Application No: A/164/21/AG
Site Address: Land south of Littlehampton Road Angmering BN12 6PN
Description of works: Notification under the Town & Country Planning (General Permitted Development)(England) Order 2015 under Schedule 2, Part 6, Class B(d) to upgrade existing agricultural track, providing access to Roundstone Farm.

Thank you for your internet representation made on 26th August 2021 which has been recorded as an objection with the comments as follows:

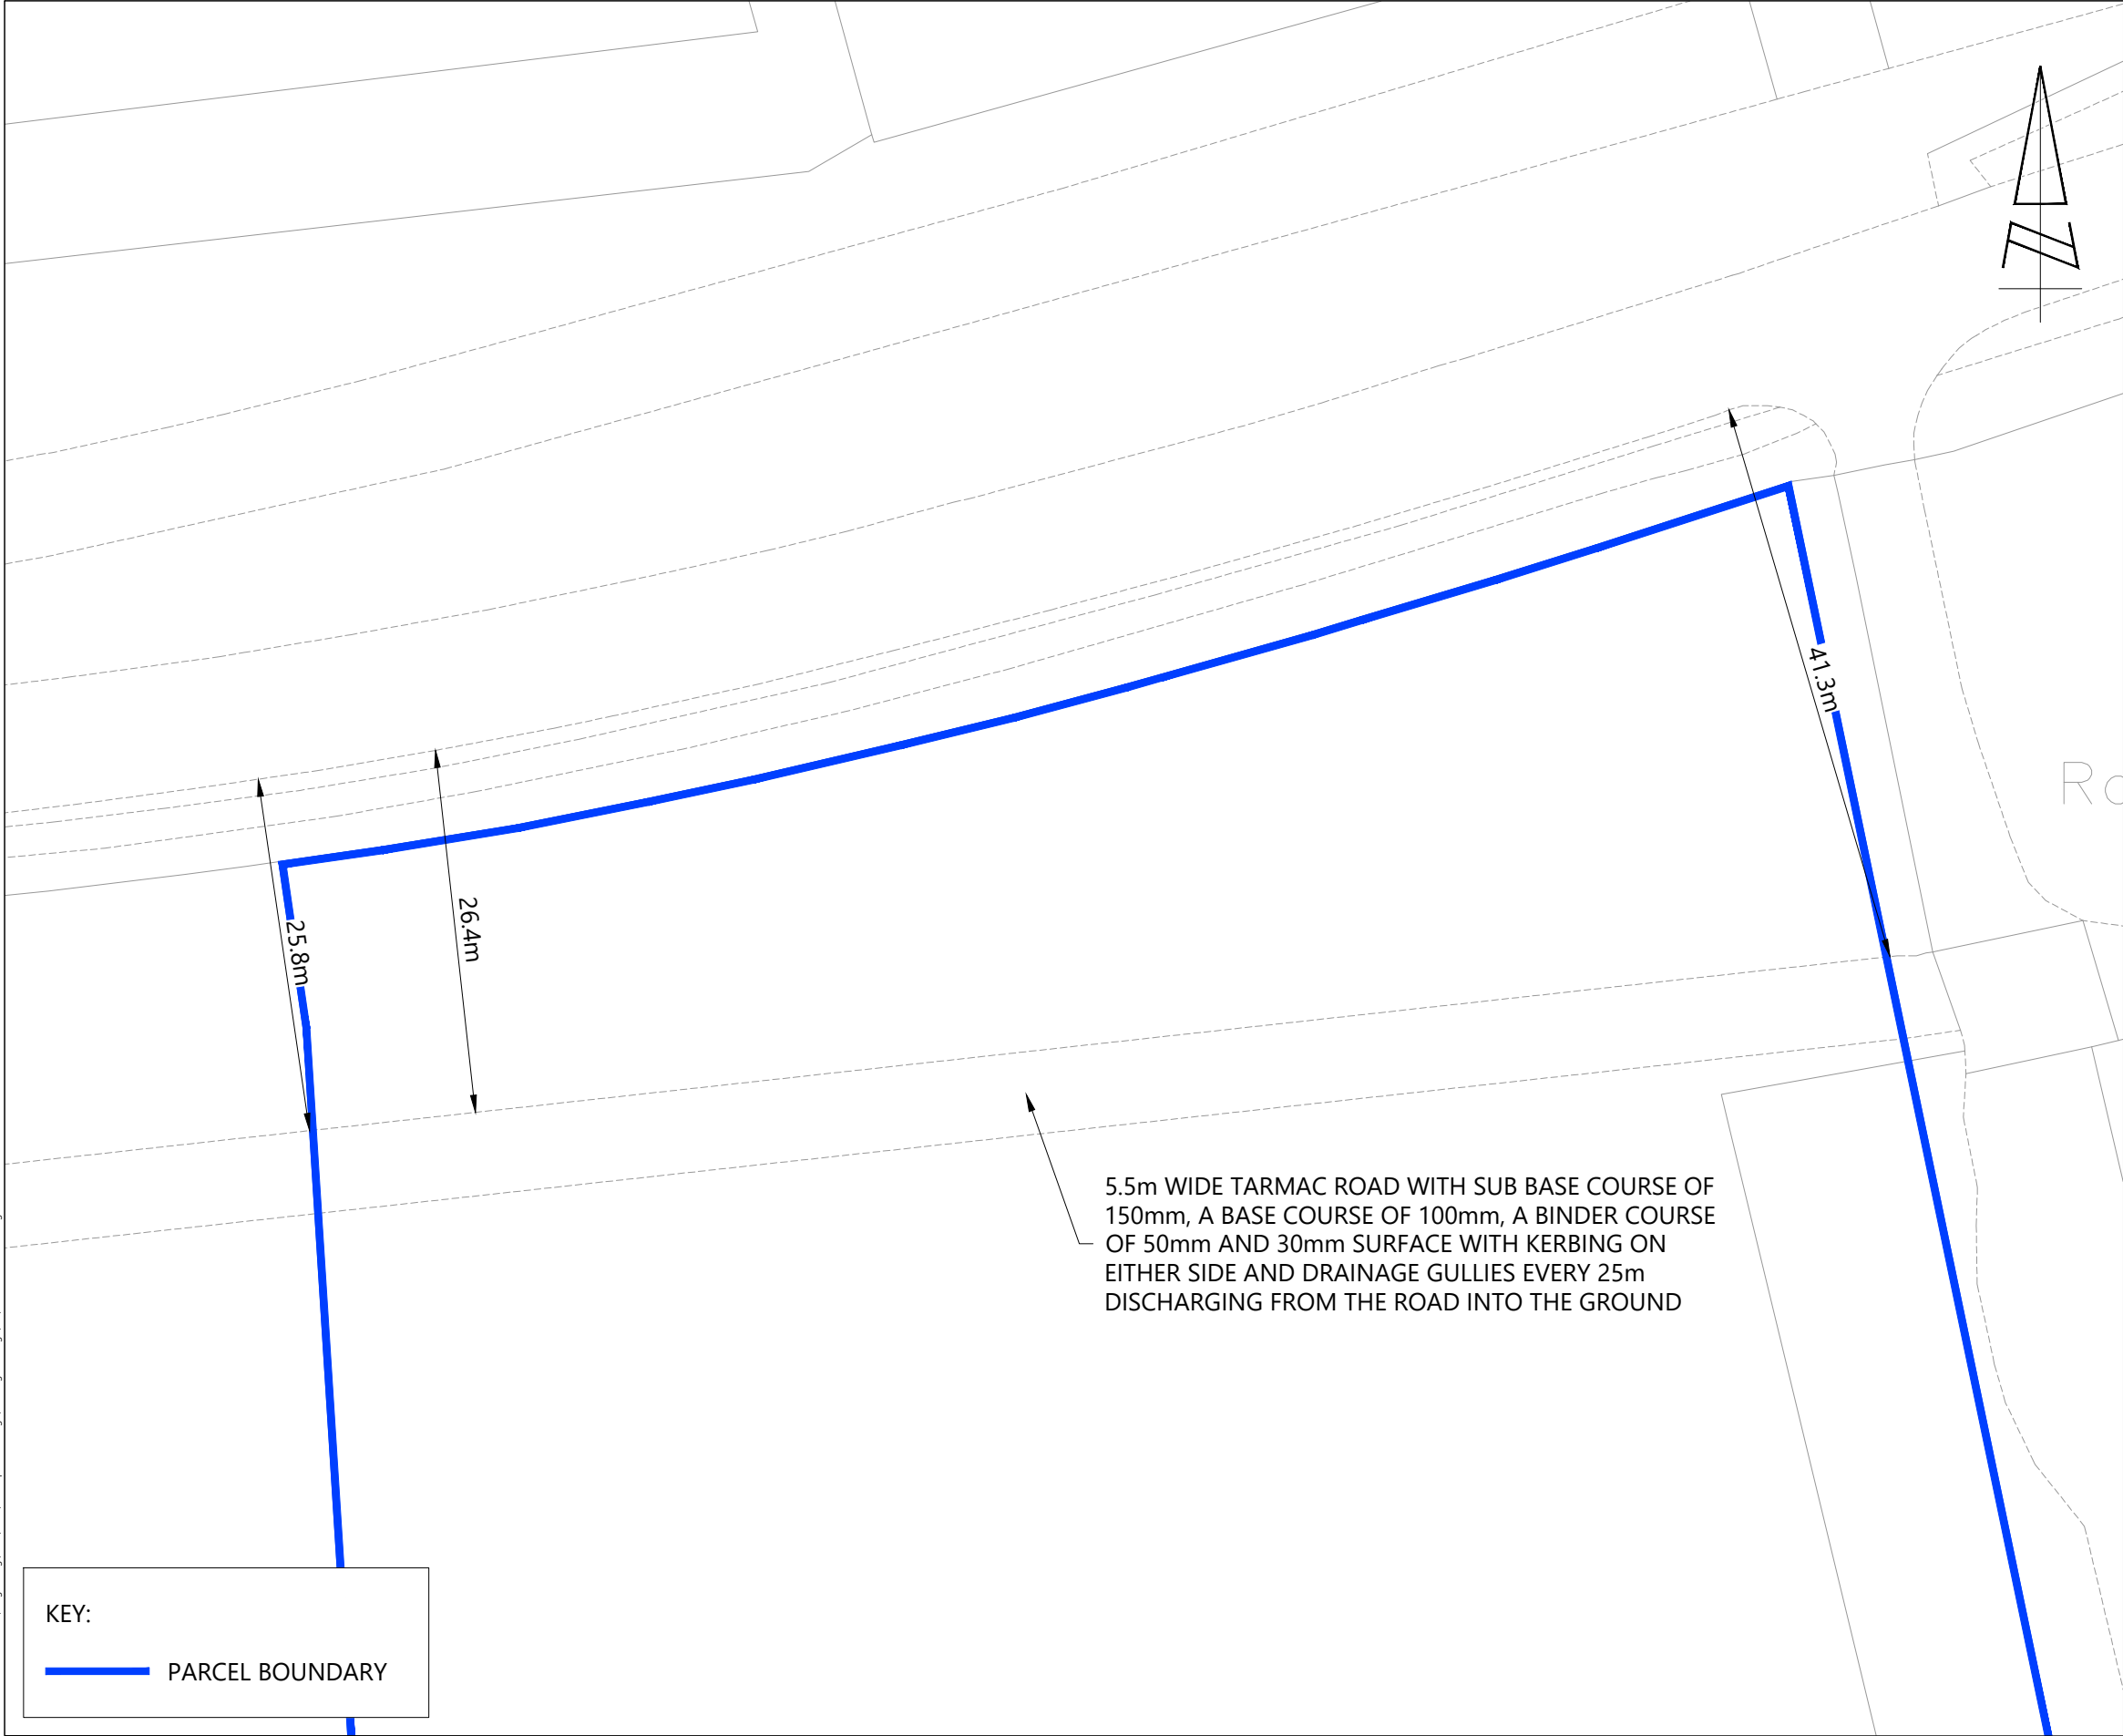
On inspection today (24/08/21) by an APC councillor, a Chartered Civil Engineer, this farm road seemed to be in a satisfactory condition for the farm traffic that currently use it. There seems to be absolutely no need to kerb and construct it to the standard proposed. It does seem that this could be an attempt to progress application A/168/21 for 76 houses on the site prior to determination. If ADC is minded to grant this application it should be conditional that the road's present and future use should be restricted to farm vehicles only and on no account used by any other vehicles accessing the farm, for any purpose, from the A259 or the A280/A259 Roundabout.
